City of Albuquerque

February 26, 2002

Re: Anderson Warehouse Grading and Drainage Plan
Engineer's Stamp Dated 1-15-02, (J14-D142)

GRADING AND DRAINAGE PLAN

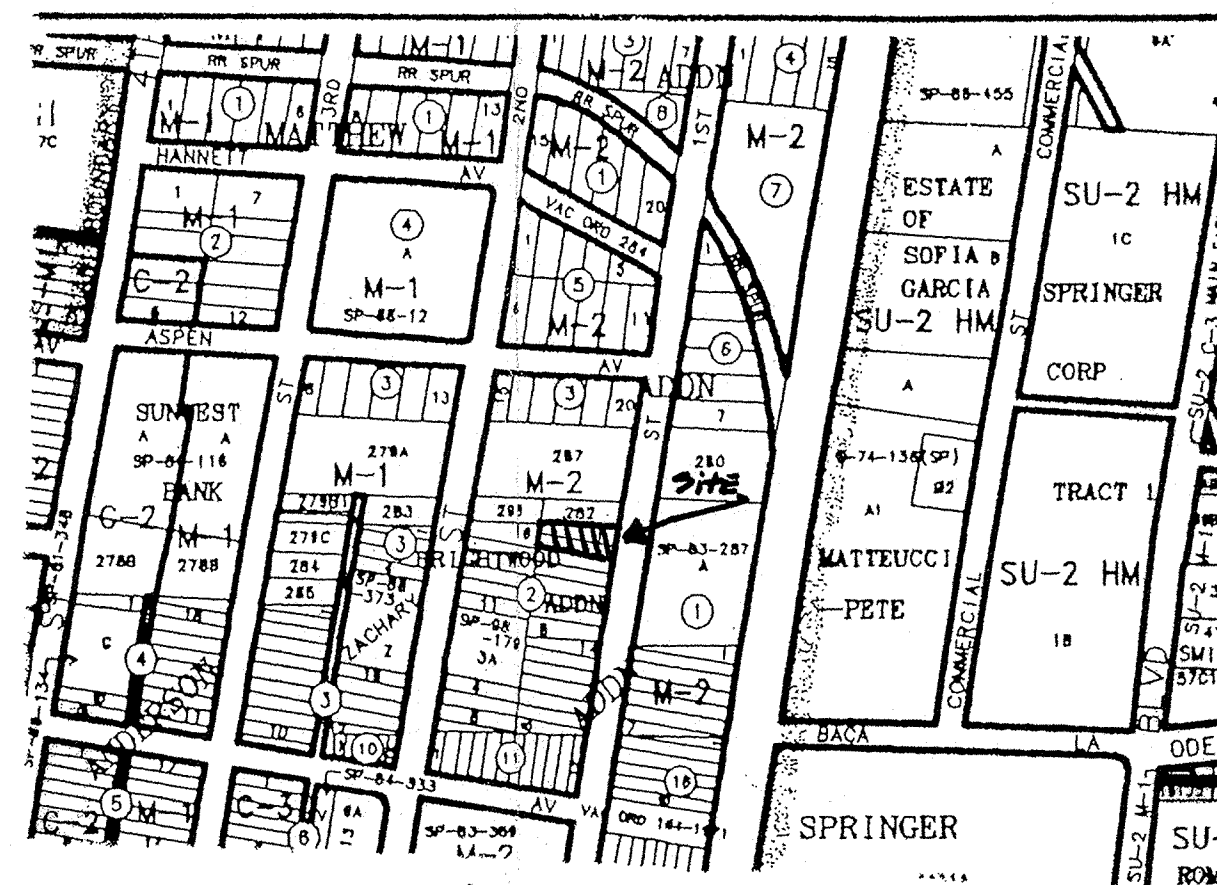
- Please address if there are any off-site flows. If there are none, please state so in your commentary.
- Please provide the peak discharge for the proposed conditions.
- Please identify the inlets on 1st street in which you make reference to on your plan.
- Please identify a 1-foot water block at the east entrance.
- The zone map should also have a north arrow designation.
- Please identify the property boundaries.
- In the down stream condition excerpt, you mention, "Free discharge has been allowed into a common pond provided by"; please mention what free discharge it was provided by. What is the capacity of the pond? Is this pond existing or proposed?

As a reminder, when a project is inclusive to a Master Plan, such as this, it should include the City drainage number of the Master Plan or include the basin map at least. As you know, a drainage plan should be able to stand-alone. Please submit this information with your next submittal. If you have any questions about my comments, you can contact me at 924-3984.
